GOODMAN PROPERTY SERVICES (AUST) PTY LIMITED  
Level 17 / 60 Castlereagh Street  
Sydney NSW 2000

Oakdale West Industrial Estate-Mod-2 (SSD-7348-Mod-2)  
**Request for Response to Submissions**

## **Attachment A: Request for further information**

Figure 3-2: Site Layout

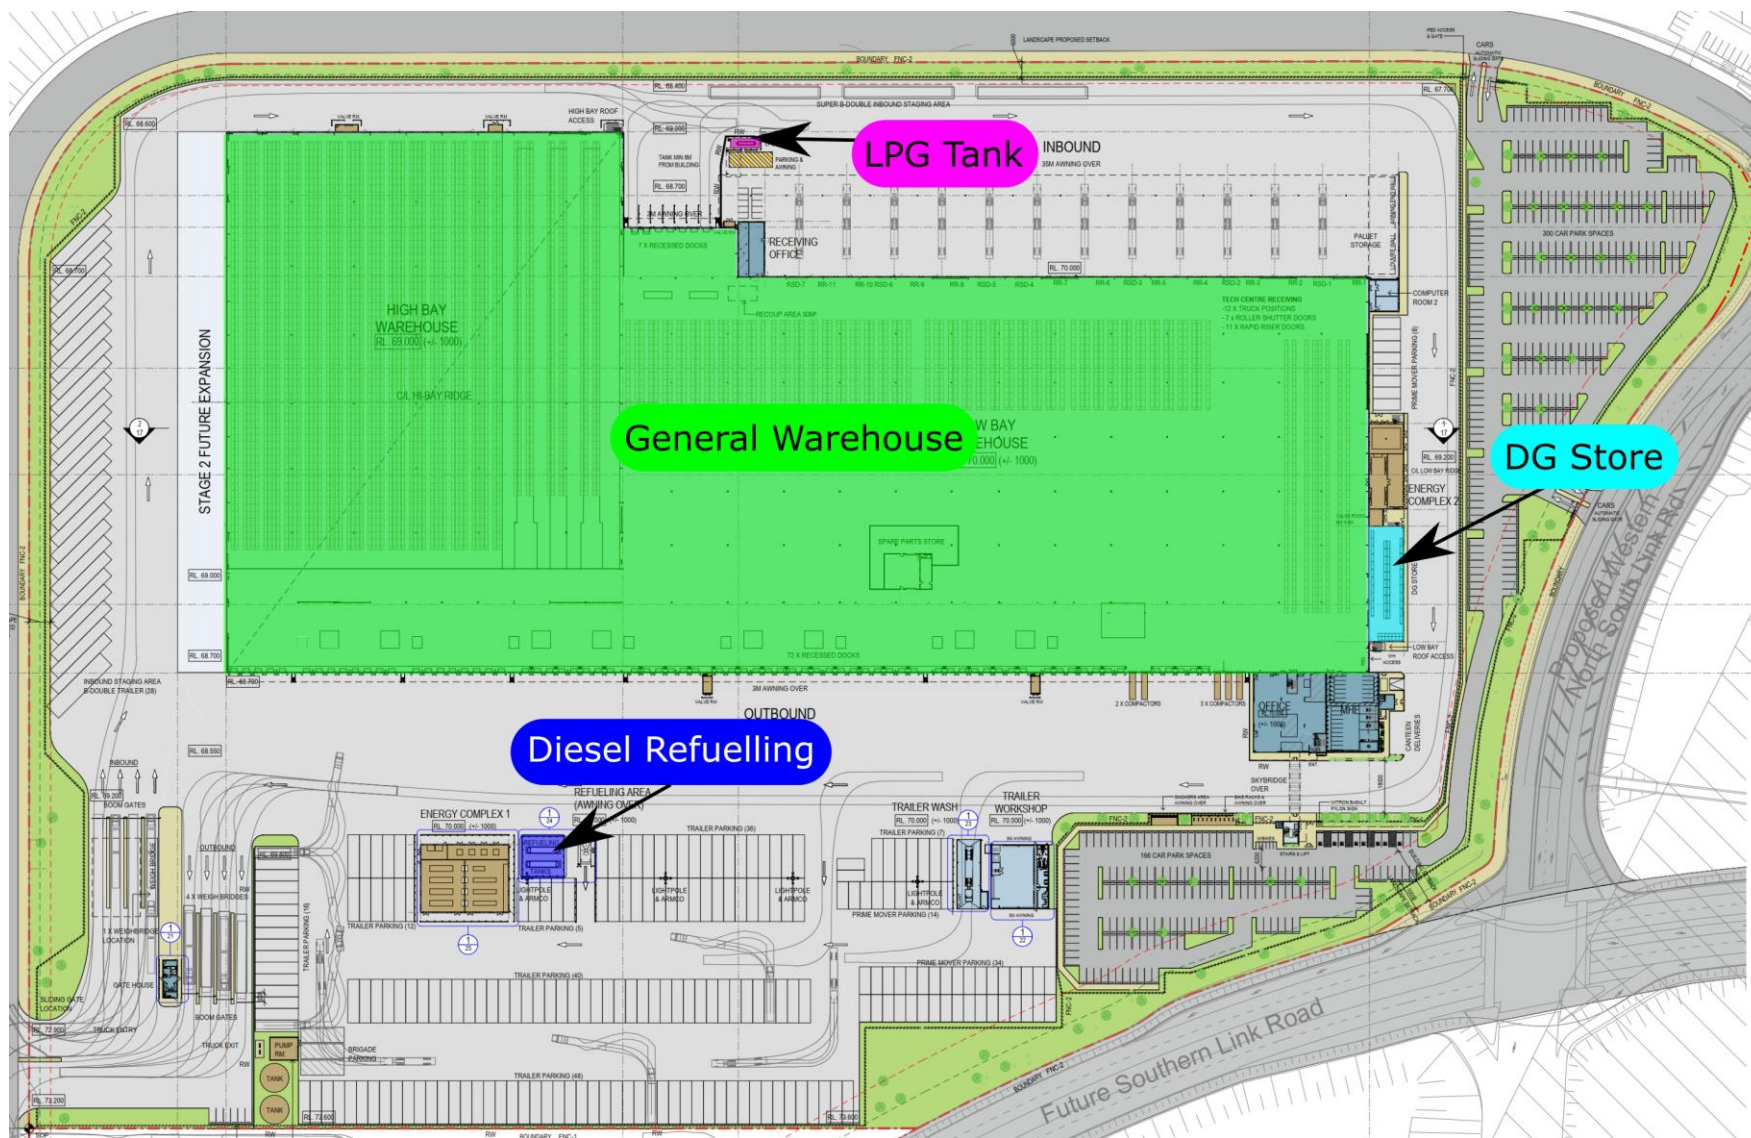
- It is noted on Figure 3-2 of PHA that the DG store and the main warehouse are sharing a common wall, and the DG store and the Energy Complex 2 are sharing another common wall. Please clarify whether these walls are fire rated.
